Plot 1 Floor Plan

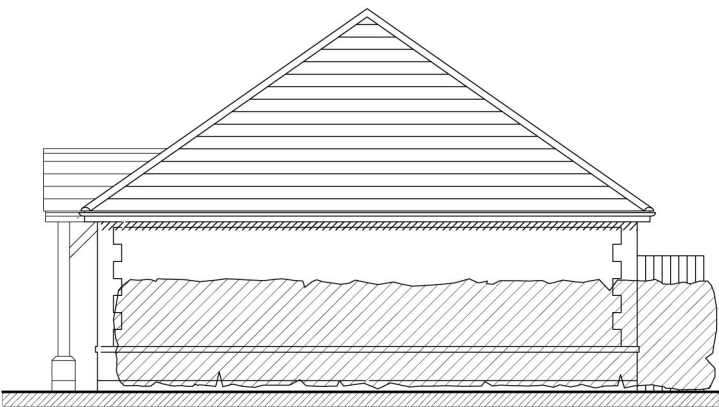
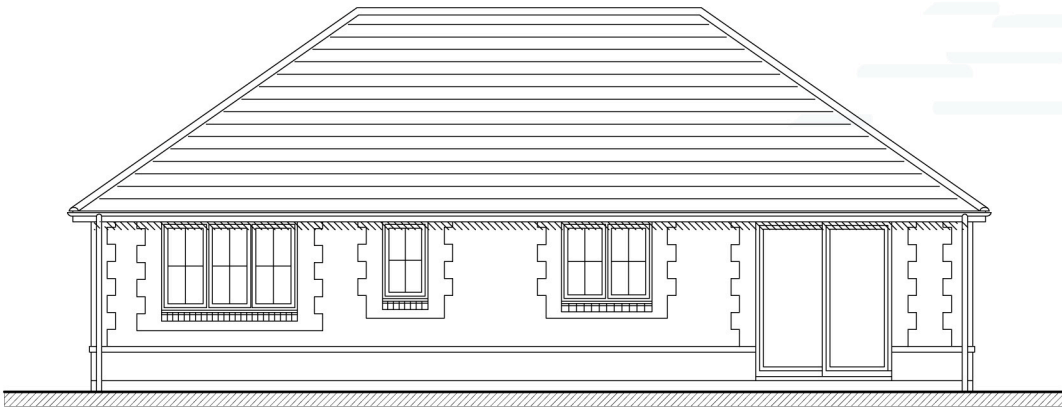
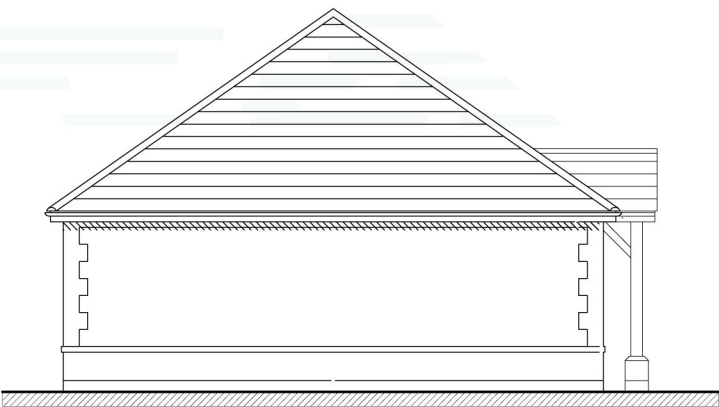
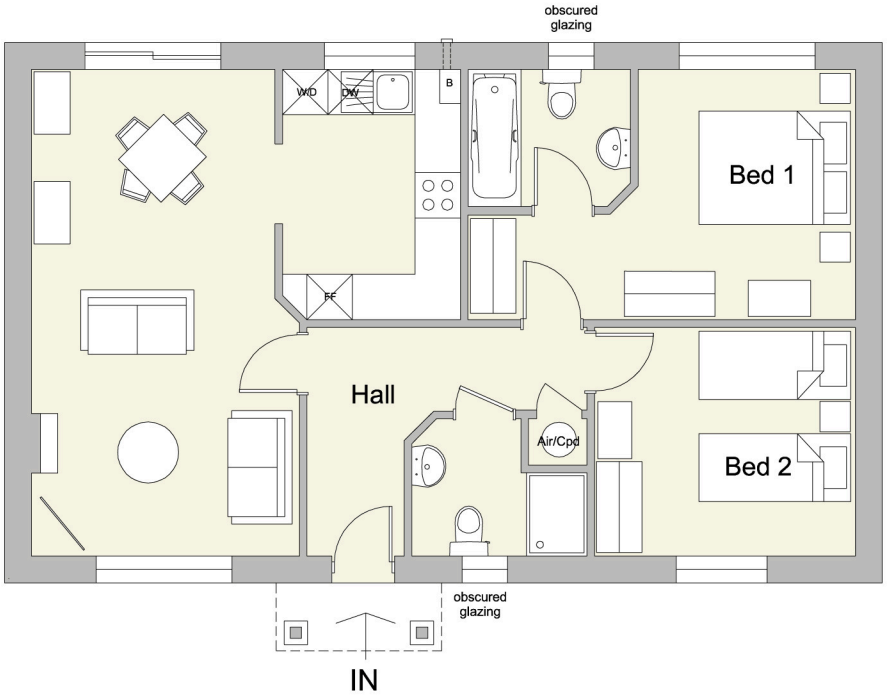
Further to our conversation this morning Plot 1 has been reduced in width and some slight amendments made to the internal layout. (New floor area is 82.3 sqm)

This has allowed us to move further away from the RPA which now measures 5.75m as the Planning Officer requested.
